Submission No.			218	
Organisation Name or Name of Submitter			Office of Public Works (OPW)	
Item No.	Section Ref.	Page No.	Observation Statement	TII Response
OPW 44/45 O'Connell Street - Re: Railway (Metrolink–Estuary to Charlemont via Dublin Airport) Order 2022 – Submissions by the Commissioners of Public Works in Ireland				
1	Report Executive Summary	23	<p>With respect to the proportion of the State's property portfolio managed by the OPW, we will endeavour to share knowledge and information with Transport Infrastructure Ireland (TII) to facilitate the successful delivery of the project through a collaborative approach.</p> <p>This submission has been prepared by DOWNEY in conjunction with Gall Zeidler Consultants, on behalf of The Commissioners of Public Works in Ireland (hereinafter the Office of Public Works (OPW)) and on foot of extensive consultation(s) with the OPW and its clients, which relates to the MetroLink route, and its relationship with Nos. 44-45 O'Connell Street Upper, Dublin 1.</p> <p>With respect to this property, the OPW is seeking:</p> <p>1) To note the subject property is owned by the OPW. Agreement with the OPW will be required prior to any works being car

Drawing Title	METROLINK - STRUCTURES O'CONNELL STREET STATION PROPOSED STREET LEVEL DESIGN	Drawing Status	S0
Drawing N°	ML1-JAI-SRD-ROUT_XX-DR-Y-02071	Plan Drawing N°	ML-ST 305 F-G1
Scales Original Size A1	1:250	Sheet	1 of 7

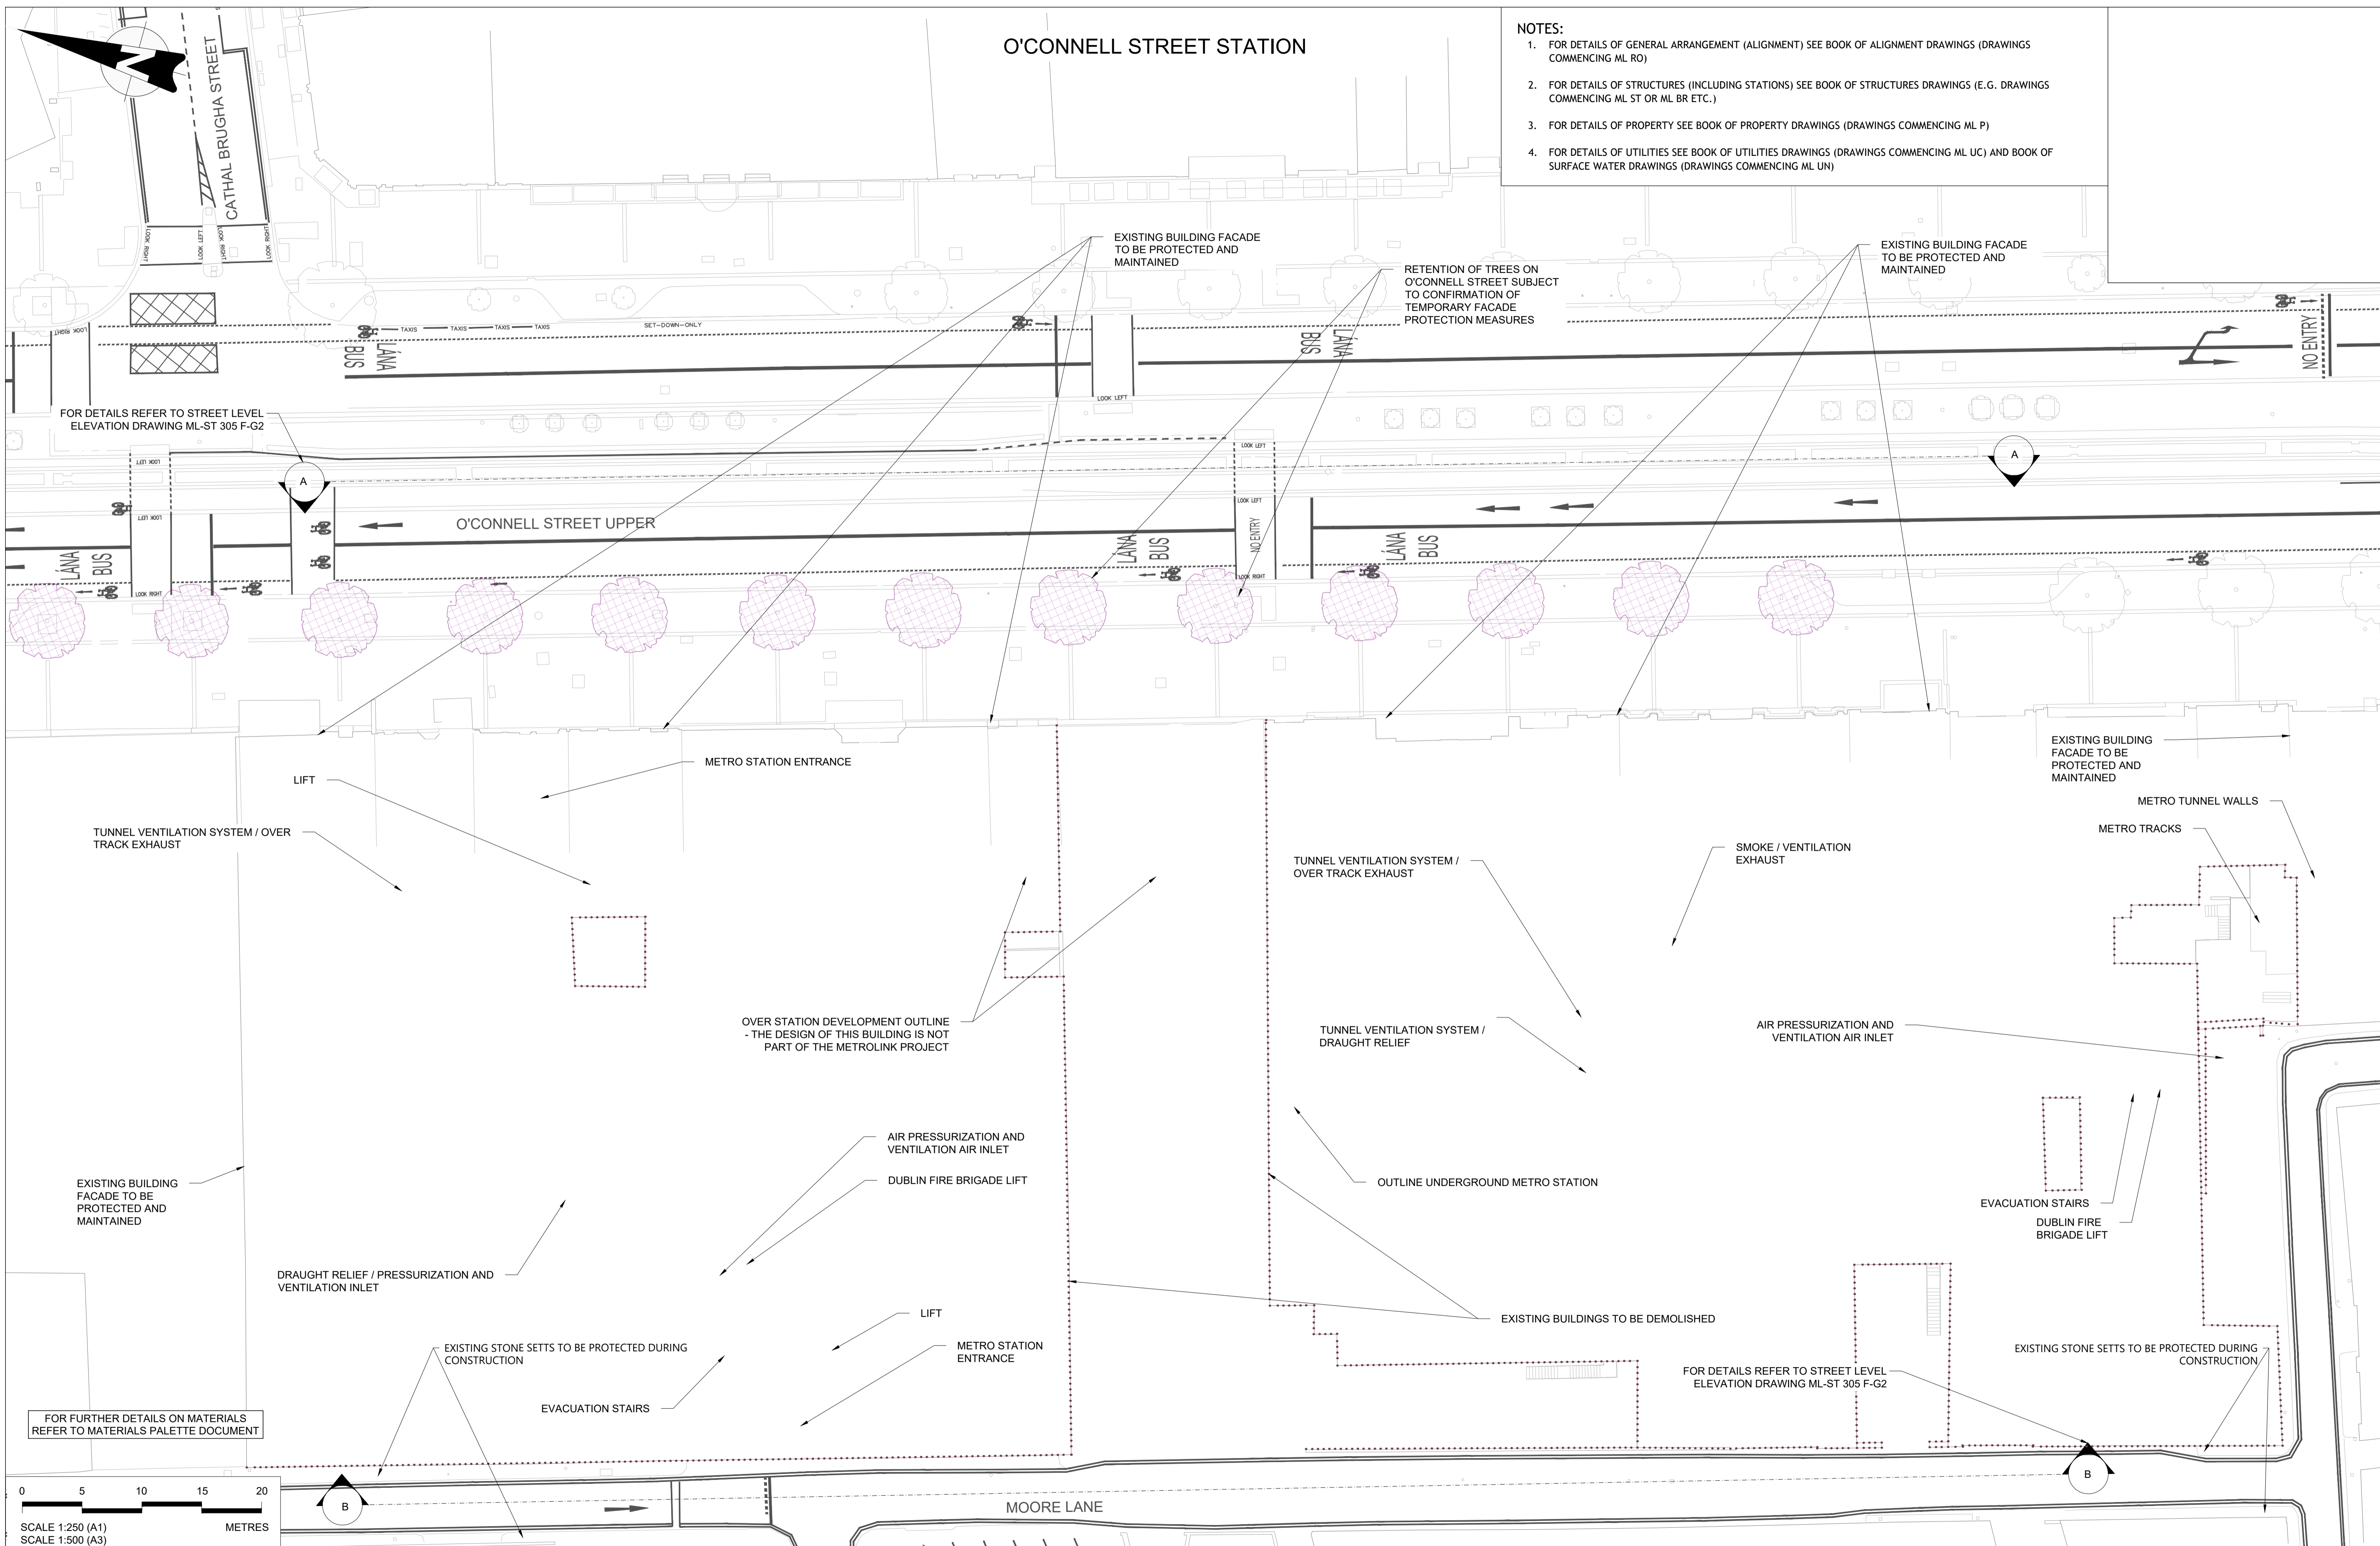
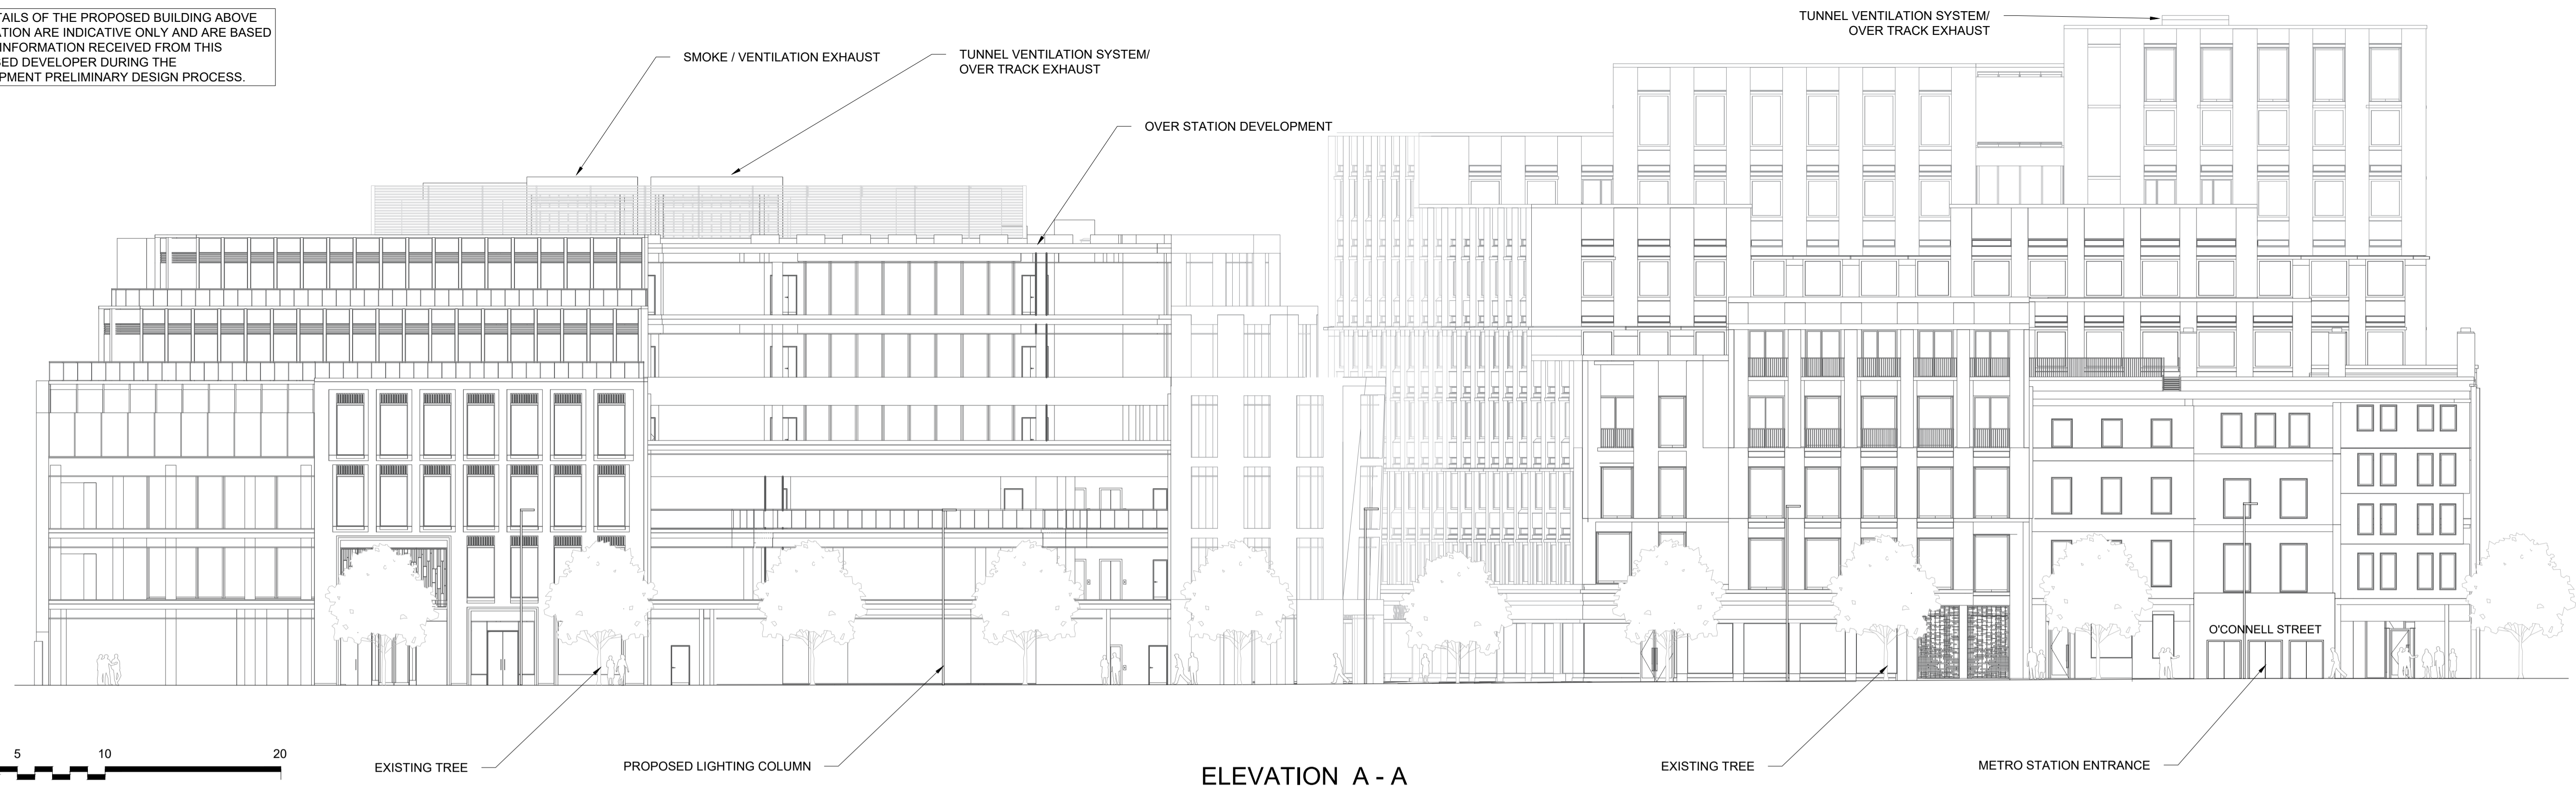
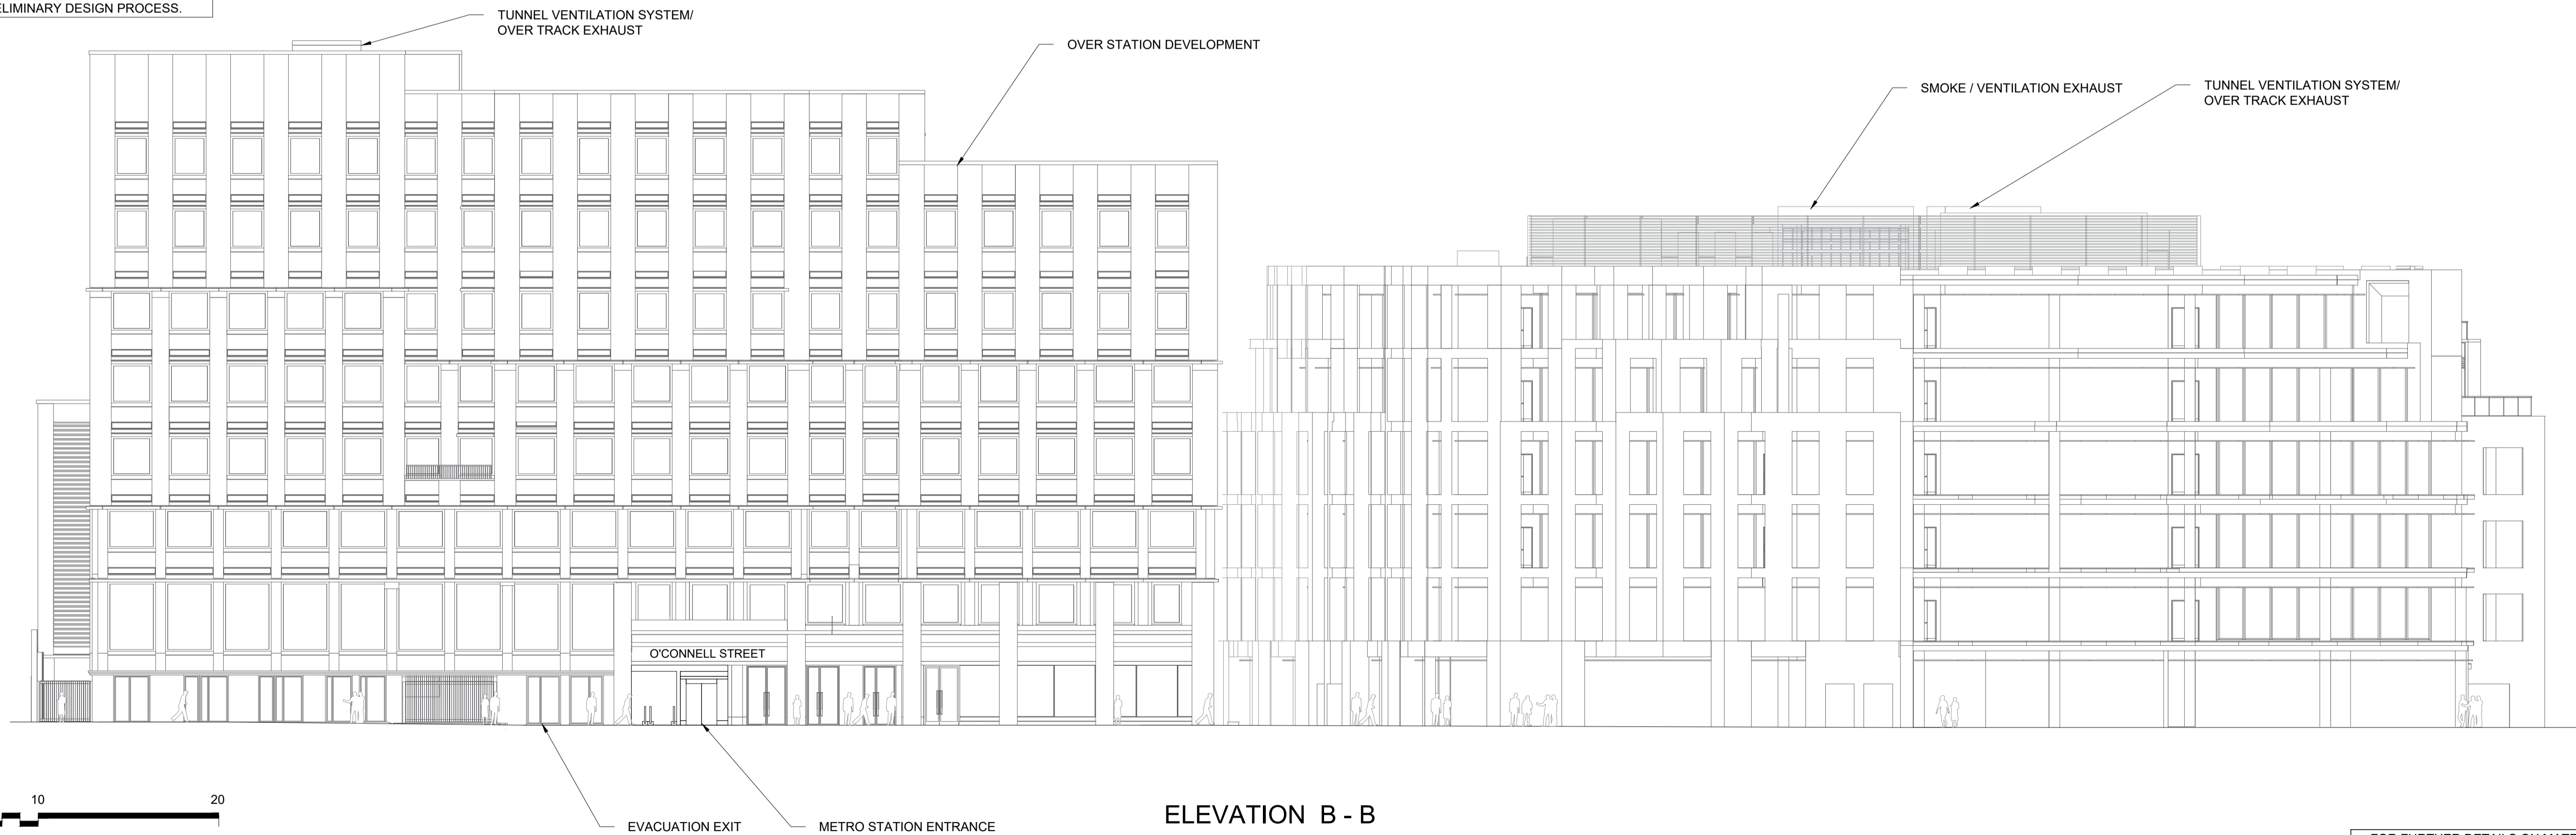
23	Potential impacts on the property	21	DOWNEY and Gall Zeidler have carried out a detailed examination of the property subject to this submission. Having regard to the status and current use of the property and identified constraints, the following raises issues regarding potential impacts of the MetroLink on the property. This has been elaborated to include potential impacts during the construction and operation phases of developing MetroLink, as well as any impediments and/or implications for future development of the property	Please note that the buildings are to be demolished, with the façades retained. The future development is by others under a separate planning application to the Railway Order, who are cognisant of the restrictions due to the station. Under the current plan, there is no development opportunity for OPW.
25	Monitoring	21	Given the sensitivity if the façade of this property, we request that An Bord Pleanála attach a condition to the Draft Railway Order that ensures continuous monitoring of the property to prevent any negative impacts. Access to all properties must be agreed in advance with the OPW. It is recommended that this monitoring takes place at least 3 months in advance of the construction of the Project and at least 6 weeks post the operational stage of the MetroLink.	Please refer to response number (10) above.

32	Conclusion	23	With respect to this property, the OPW is seeking: 1) To note the subject property is owned by the OPW. Agreement with the OPW will be required prior to any works being carried out to 44/45 O'Connell Street. The façade to 44/45 O'Connell Street is a Protected Structure to be retained and incorporated into the O'Connell Street Station Entrance. 2) To ensure no interference with or damage to the façade of the building and its architectural detailing, pre-construction and post-construction surveys, trials, and monitoring is required. This is mainly concerned with demolition, noise, vibration, and dust which can damage the buildings, which is of historical significance. 3) To ensure the appropriate conservation and structural appraisals are conducted as part of the Detailed Design Assessment. 4) Precedents to be applied to the risk assessments to ensure utilising best industry practice within implementation of the Project. In light of the above, DOWNEY respectfully request that An Bord Pleanála take into consideration the issues raised by the OPW when assessing the Draft Railway Order 2022 (MetroLink - Estuary to Charlemont via Dublin Airport).	TII response to comments: 1) The façades will be retained and incorporated into subsequent development. 2) Pre and Post construction surveys will be undertaken and proposals developed so as to minimise any impacts. 3) Agreed. 4) TII will implement industry best practice risk management techniques.
